Our Ref: R/187/17/HH

**Town & Country Planning Act 1990 (as amended)
Town & country Planning (Development Management Procedure) (England) Order 2015
Application for Householder Planning Permission**

Development First floor side extension
Location 48 Dinsdale Gardens Rustington

ELEVATIONS.

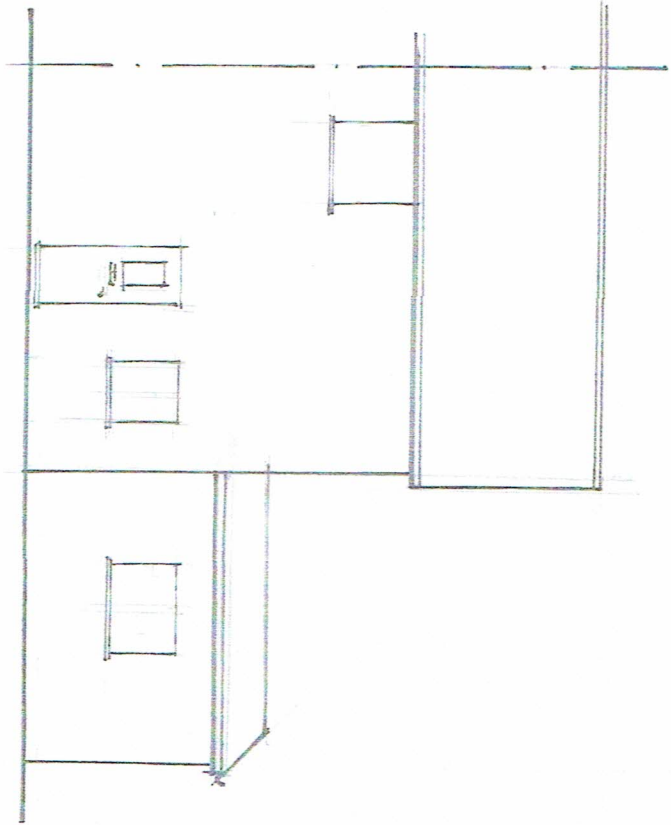
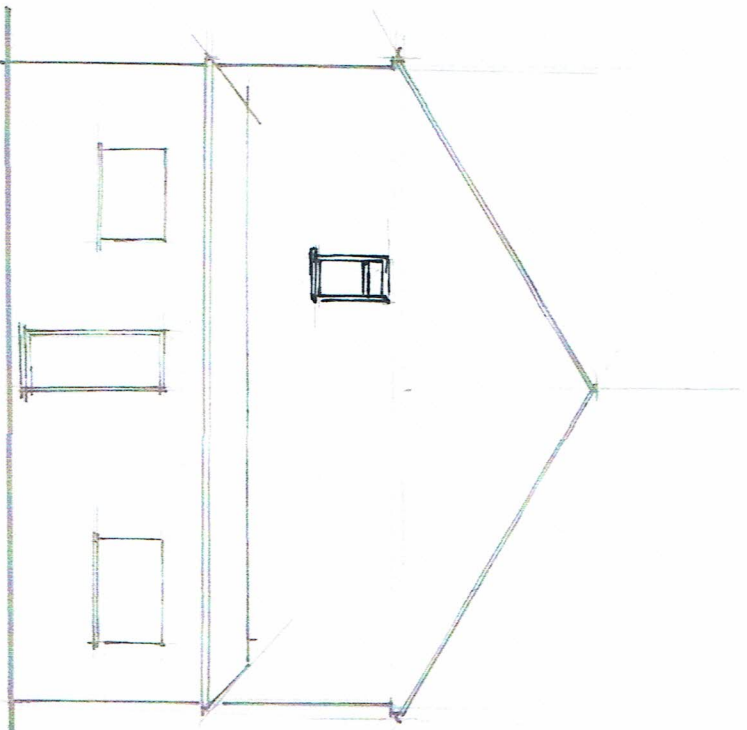
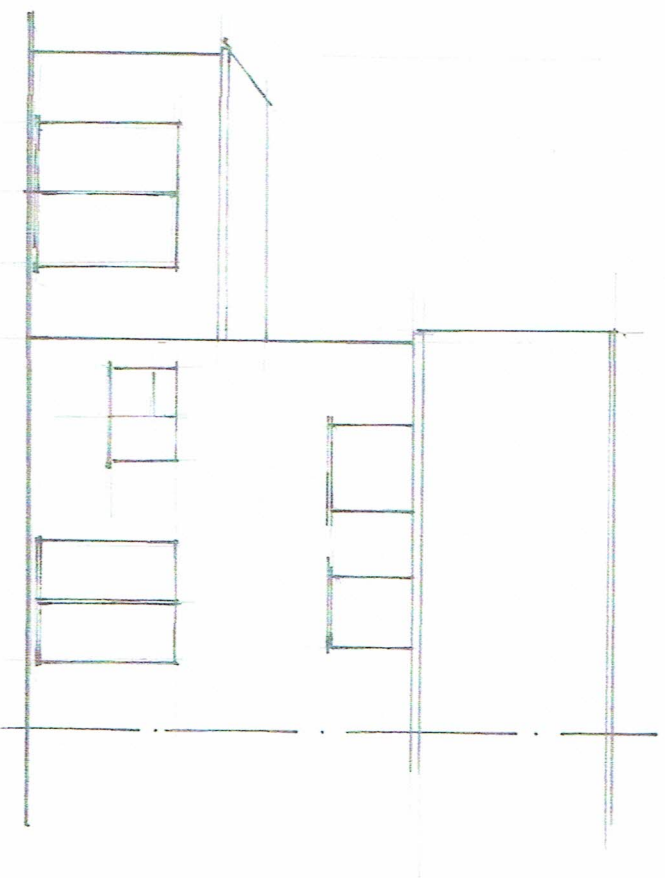
The existing north first floor plan and elevation do not accord. Please amend accordingly.
